**WEST SUSSEX COUNTY COUNCIL
PLANNING SERVICES CONSULTATION**

DATE: 09th January 2018

SUBJECT: LU/390/17/PL - Demolition of existing building & erection of 1 No. retail unit & 3 No. flats above with associated external works & access. This application may affect the setting of Listed Buildings & the character & appearance of the Littlehampton (River Road) Conservation Area.

Littlehampton Covered Market, 26-28 Surrey Street, Littlehampton, BN17 5BG

Drawing title
Proposed Site

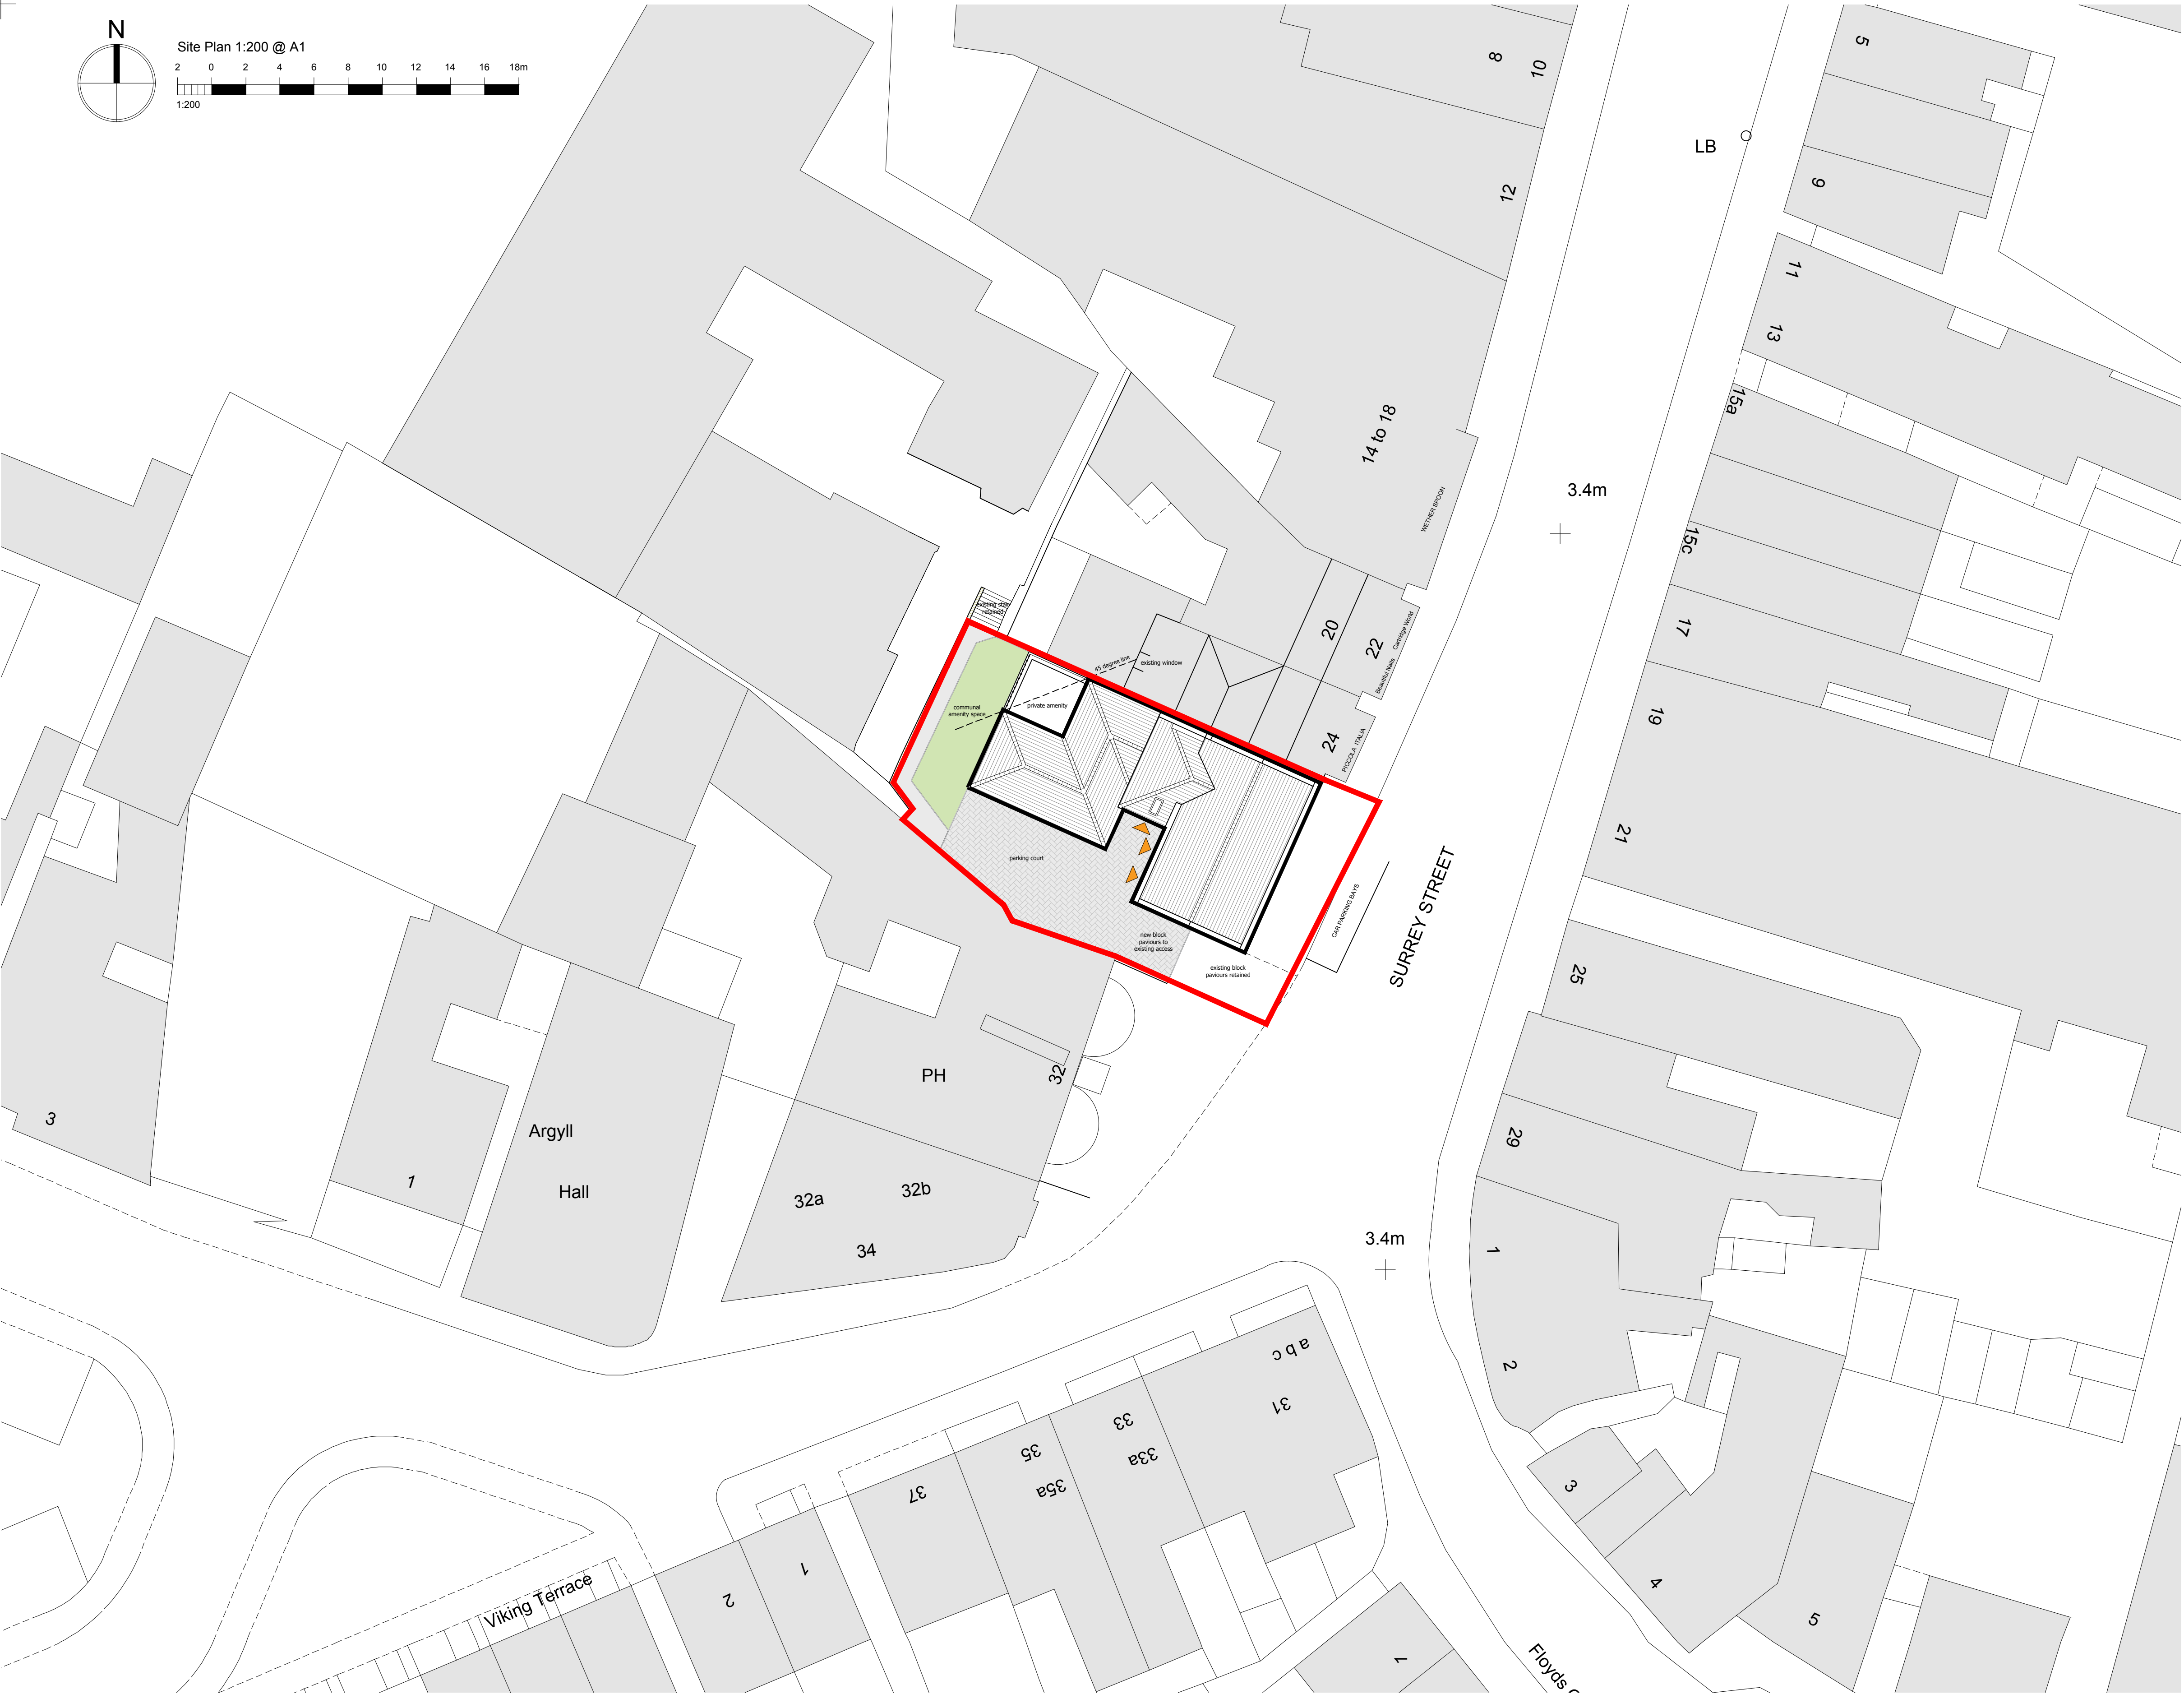
Three car parking spaces will be provided, presumably one allocated to each residential unit. These will be accessed via an existing point of access from Surrey Street located at the southern extent of the plot. I'm not aware of the use of this access point in the past but it likely provided service/staff parking for 26-28 Surrey Street. On balance the use of this access to serve the residential parking would not result in a material intensification of use at this access point onto the maintained network.

The proposed spaces are appropriately sized and provided enough manoeuvring room to facilitate a turn on site.

A secure and covered cycle parking provision should be provided for the residential dwellings in the interest of sustainability.

Upon inspection of the plans provided it does not appear that the physical built will extend beyond the existing building and therefore not result in building on land considered to be public highway. It is noted that an annotation for 'new block pavements to existing access' is located on land considered public highway. Any works of the public highway must be implemented under licence to a specification obtained from WSCC Highways.

No part of the development shall be first occupied until the car parking has been constructed in accordance with the approved site plan. These spaces shall thereafter be retained at all times for their designated purpose.

No part of the development shall be first occupied until covered and secure cycle parking spaces have been provided in accordance with plans and details submitted to and approved by the Local Planning Authority.

The applicant is advised to contact the Highway Licensing team (01243 642105) to obtain formal approval from the highway authority to carry out the site access works on the public highway.
